Project#1009046 Duke City Lumber Co (Sawmill Crossing)
13DRB-70735 Amendment to Preliminary Plat

14DRB-70273 VACATION OF PUBLIC WATERLINE & SEWER EASEMENTS
 14DRB-70274 SIDEWALK WAIVER
 14DRB-70275 - TEMP DEFR SWDK CONST
 14DRB-70276 - PRELIMINARY PLAT

MARK GOODWIN AND ASSOCIATES, P.A. agents for SAWMILL CROSSING, LLC request the referenced/ above actions for all or a portion of Tract B, **SAWMILL CROSSING Unit 1**, zoned SU-2/SU-1 for PRD, located on the south side of ASPEN AVE NW west of 12TH ST NW containing approximately 4.247 acres. (H-13)

Project #1009046—all or a portion of Tract B, Sawmill Crossing, Unit 1

VACATION EXHIBIT  
 FOR  
 TRACT B-1-A-2  
 DUKE CITY LUMBER COMPANY ADDITION  
 SAWMILL CROSSING SUBDIVISION, UNIT 1  
 WITHIN THE  
 TOWN OF ALBUQUERQUE GRANT  
 PROJECTED SECTION 7 TOWNSHIP 10 NORTH,  
 RANGE 3 EAST, N.M.P.M. CITY OF  
 ALBUQUERQUE BERNALILLO COUNTY, NEW  
 MEXICO FEBRUARY, 2012

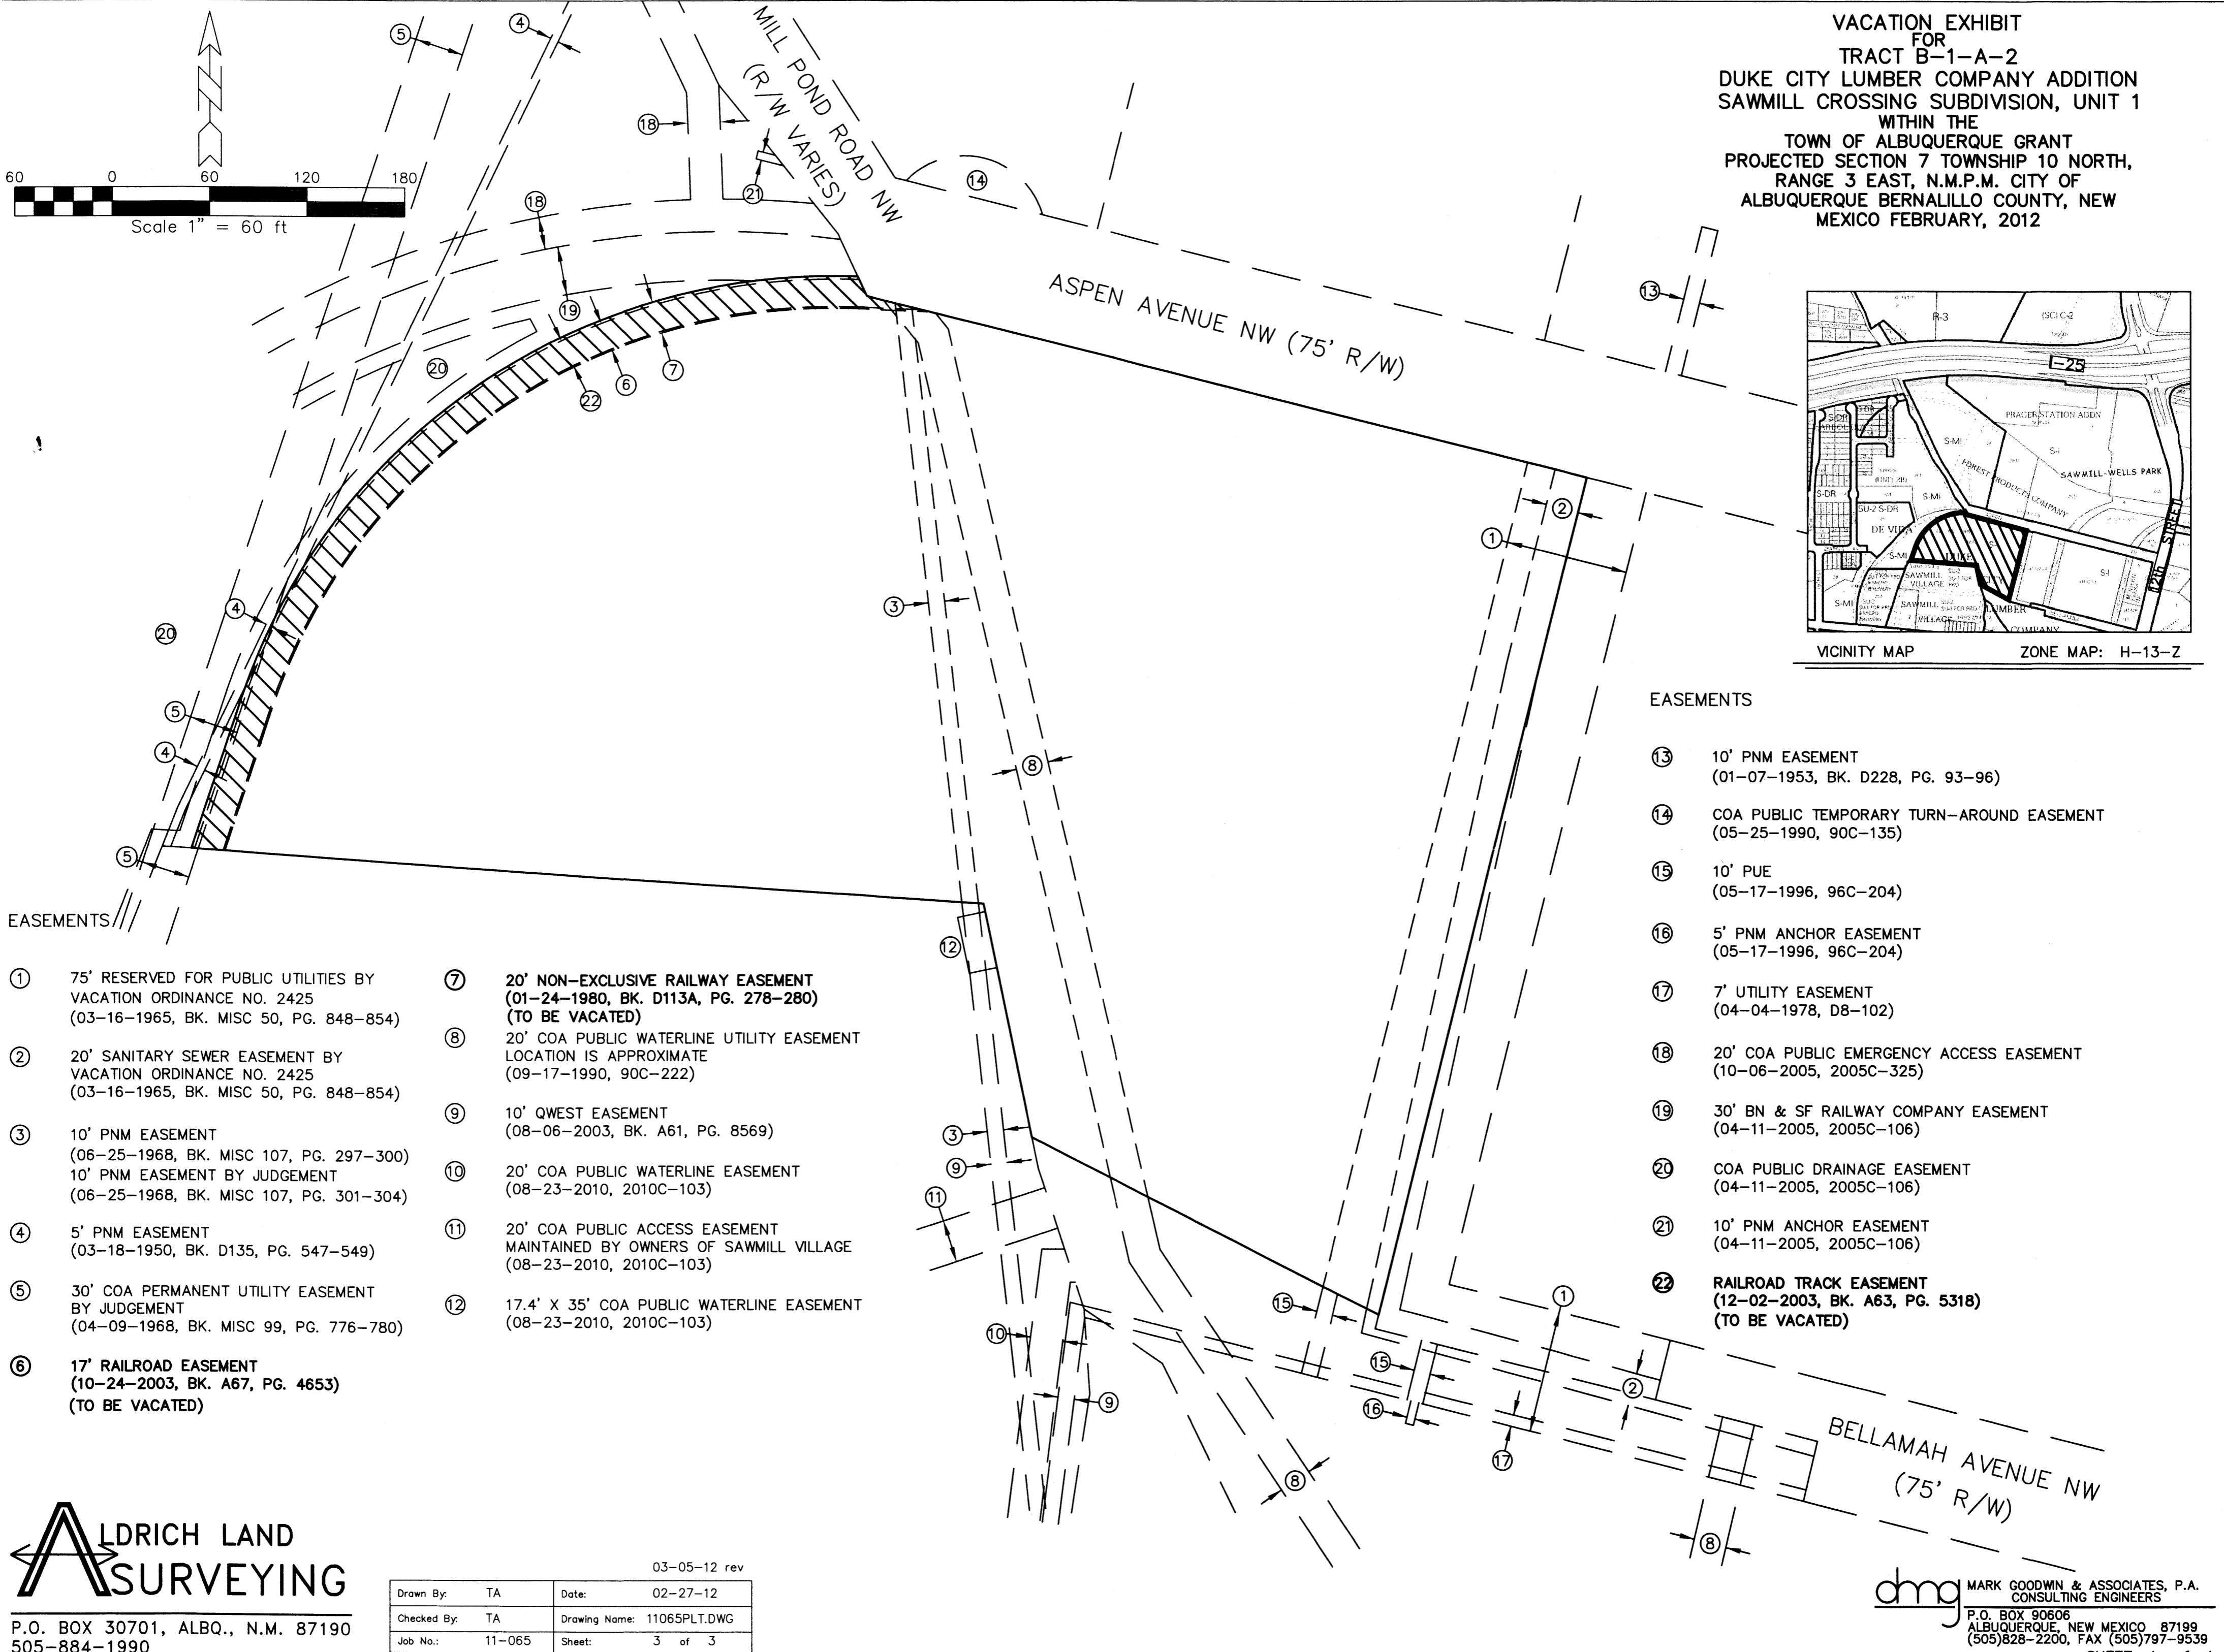
Refer to comments from ABCWUA and any public hearing comments regarding proposed vacation. Refer to comments from Transportation Development regarding proposed sidewalk variances; 'Waivers' and 'Temporary Deferral' should be on the same exhibit, with a third legend symbol for 'Sidewalks to be Built.' Sideyard sidewalks (Lots 52 & 80) typically are built and not deferred.

LANDSCAPE PLAN  
SCALE: 1" = 50'

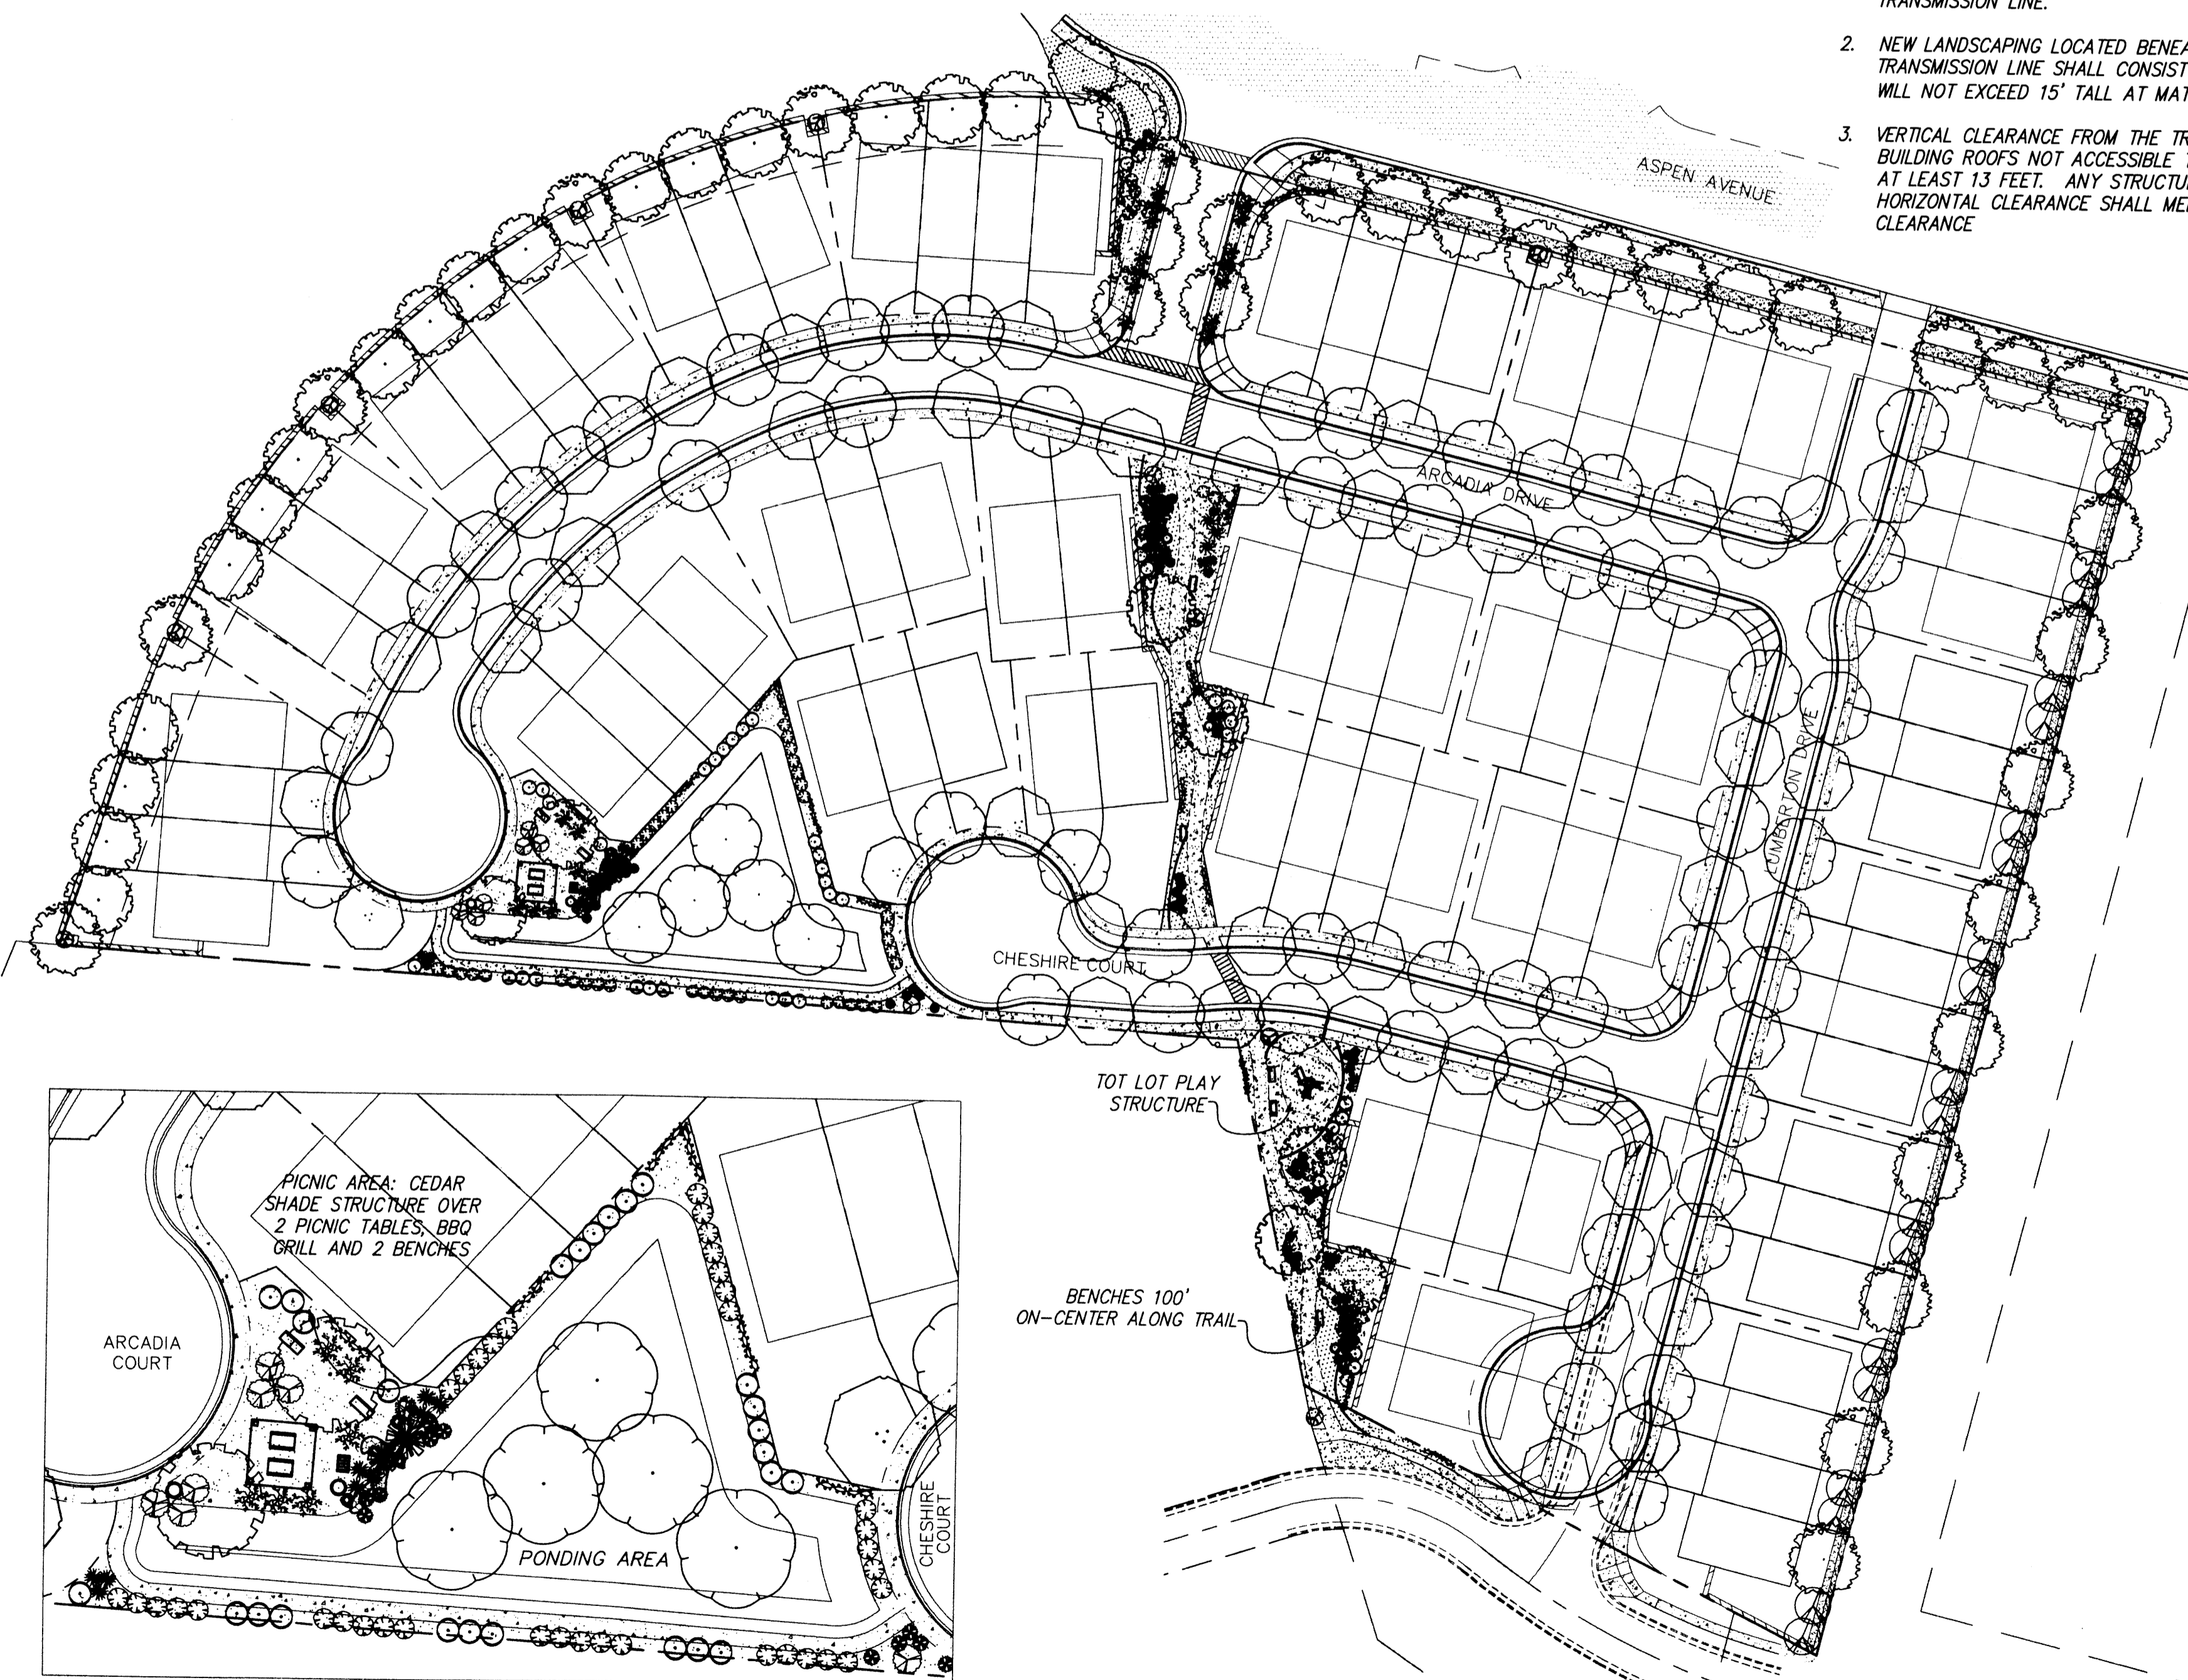
It is our recommendation that the play equipment and park furniture be situated outside limits of drainage ponding areas for safety and maintenance concerns. Maintenance and replacement can become a burden to the HOA. ADA access must be provided per Federal Title 2 Guidelines and compliance with ASTM materials must be followed by the Developer/HOA.

**PLAT FOR
SAWMILL CROSSING UNIT 1**
WITHIN
THE TOWN OF ALBUQUERQUE GRANT
PROJECTED SECTION 7
TOWNSHIP 10 NORTH, RANGE 3 EAST, NMPM
CITY OF ALBUQUERQUE
BERNALILLO COUNTY, NEW MEXICO
DECEMBER, 2013

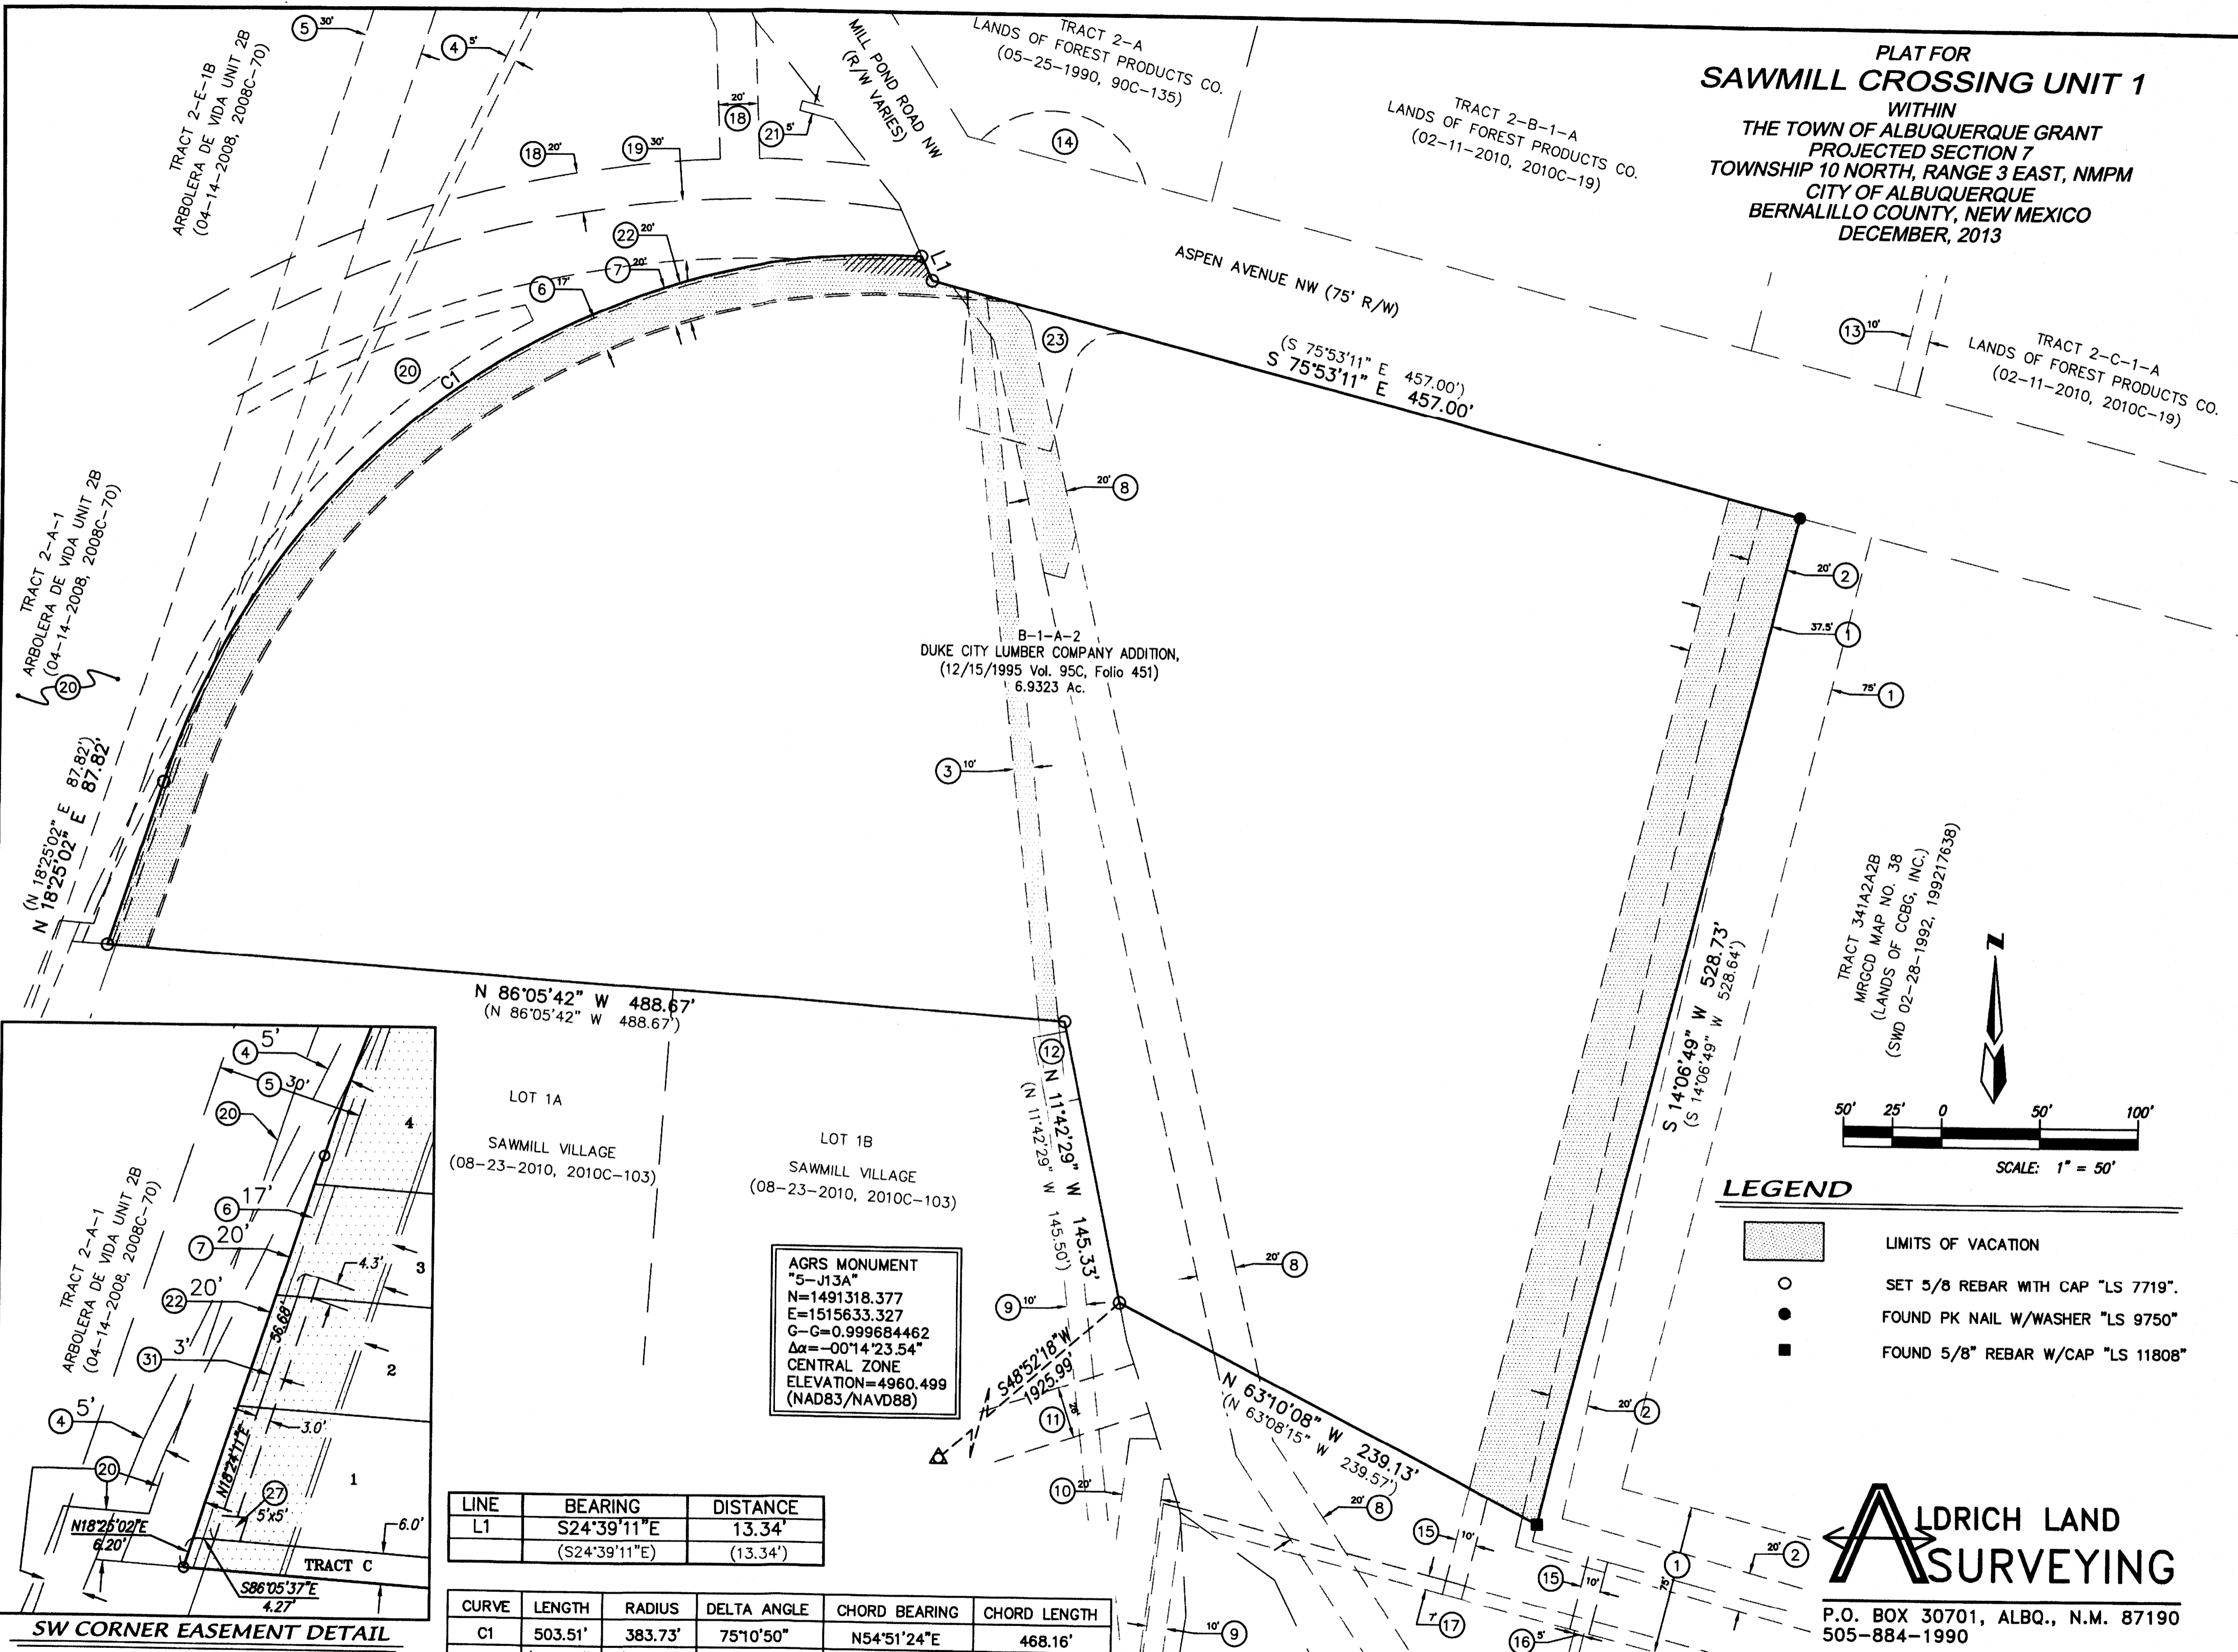
Maintenance and beneficiaries for common Tracts need to be noted on the plat, along with blank reference lines for recording information of Covenant/ Agreement on Tract C.
